STATE OF NORTH CAROLINA
DEPARTMENT OF TRANSPORTATION

Addendum No. 1

RE: Contract ID: C200893
WBS # 34336.3.4
Robeson County (R-513BB, R-513C)
US-74 From West of SR-1157 (Henry Berry Road)
To West of SR-1164 (Back Swamp Road) and From
West of SR-1164 to NC-41.

October 19, 2004 Letting

PROJECT REFERENCE NO.	SHEET NO.
R-513C	UC-19
DESIGNED BY: CSG	
DRAWN BY: CSG	
CHECKED BY: MRB	
APPROVED BY: RBW	
REVISED:	
NORTH CAROLINA DEPARTMENT OF TRANSPORTATION	
DESIGN SERVICES UNIT PHONE: (919) 250-4128 FAX: (919) 250-4119	
UTILITY CONSTRUCTION PLANS ONLY

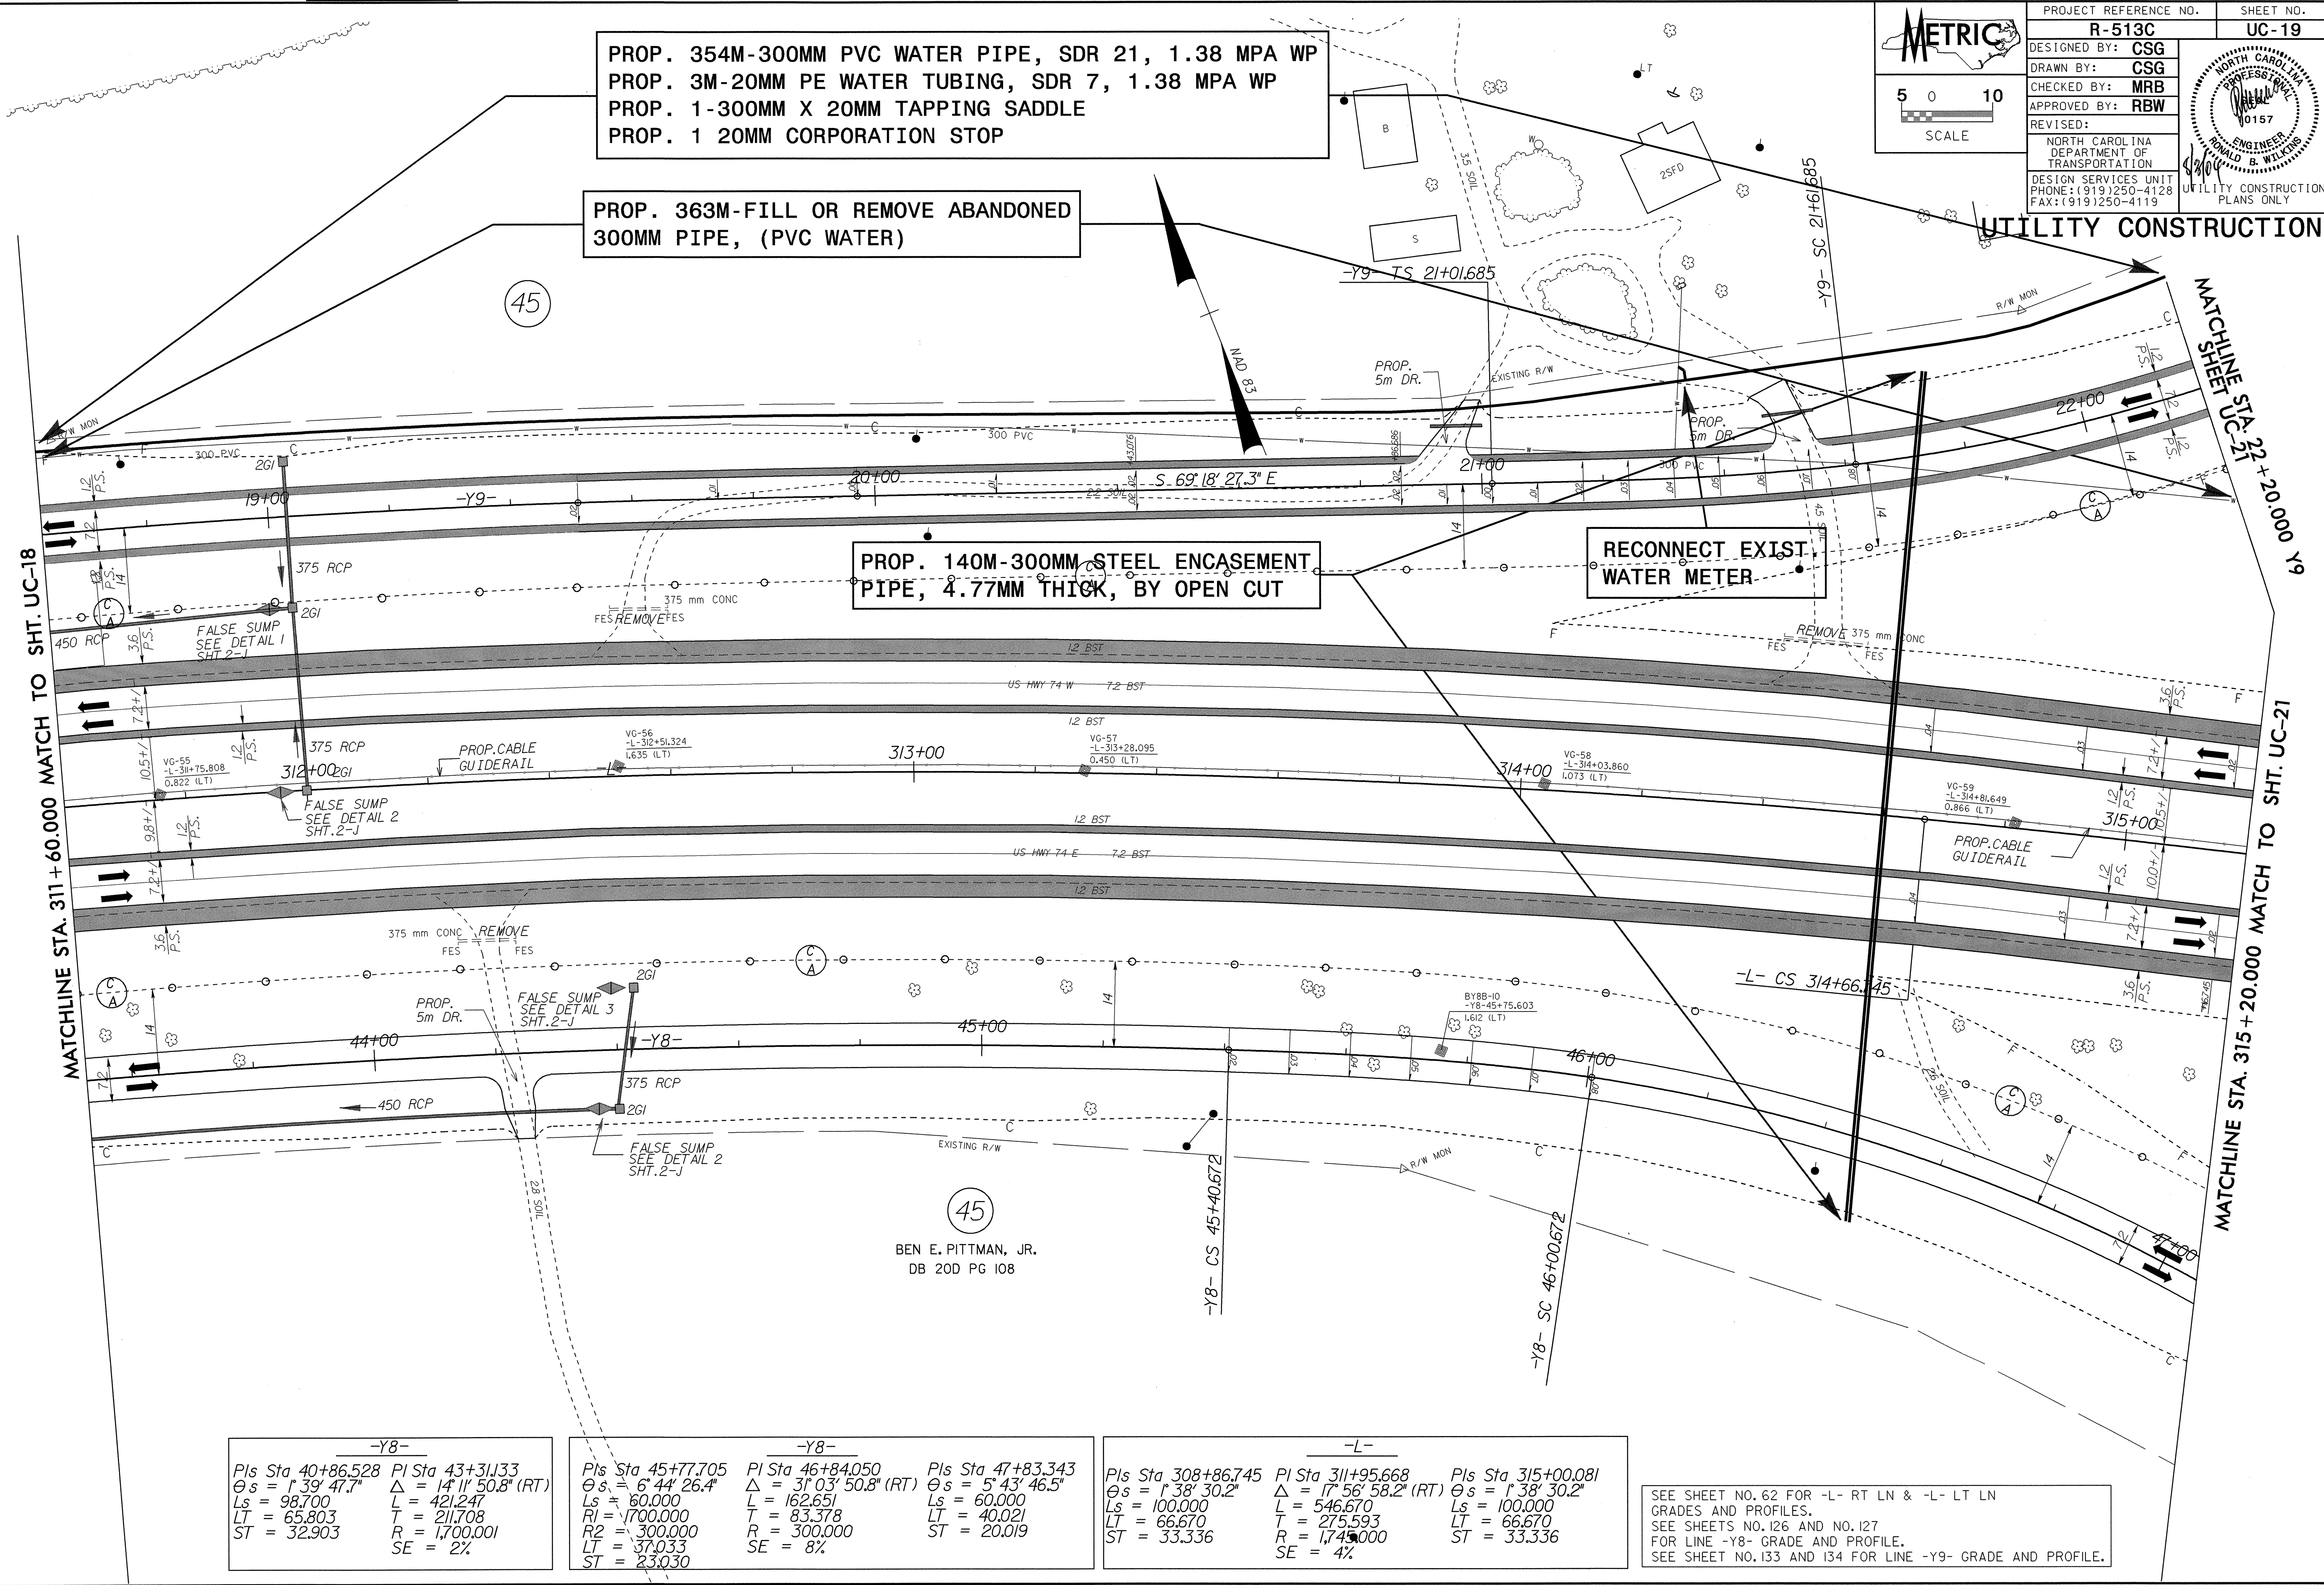
UC-1, UC-2, UC-12, UC-13, UC-15, UC-16, UC-19, UC-22 and UC-23.

On Page No. 16 of the item sheets a change has been made to the diameter and thickness for line item "259-5888000000-M-SP 3.00 MM Steel Encasement Pipe, 4.77 MM Thick, By Open Cut." By copy of this addendum the diameter is hereby changed to "600MM" and the thickness is hereby changed to "6.35MM." The Contractor's bid price shall be based on this revised pay item description. The contract will be prepared accordingly.
